**From:**  
**To:** [DCAdmin](#)  
**Subject:** Ref: planning application 2021/92471  
**Date:** 28 July 2021 16:24:17

Ref: planning application **2021/92471** 114 Hartshead lane ,Hartshead

REAR ELEVATION
1:100

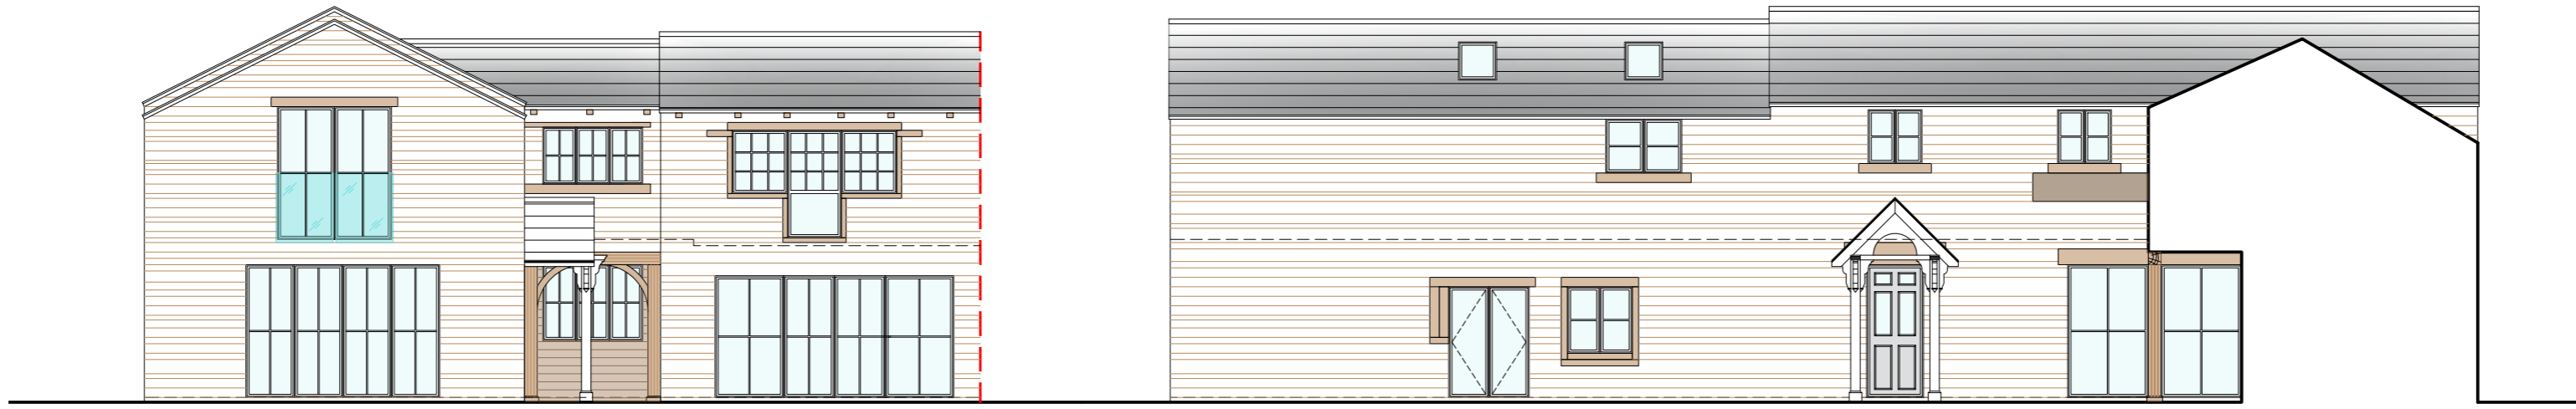
- 1, On the rear elevation plan the 1<sup>st</sup> floor extension and fitted with patio type doors will overlook onto my driveway, garage and rear gardens resulting in a loss or privacy for myself and any future occupiers
- 2, On the side elevation facing onto the front of my property and garden, the roof window to be fitted onto the already existing roof ,will also further add to a loss of privacy for myself
- 3, On as will the two roof windows which are to be fitted to the 1<sup>st</sup> floor extension, one of which will have a clear view into my first floor bedroom window on my gable end
- 4,I believe these 3 rooflights and the extension could create a precedent making it difficult to object to any similar proposals overlooking my property .
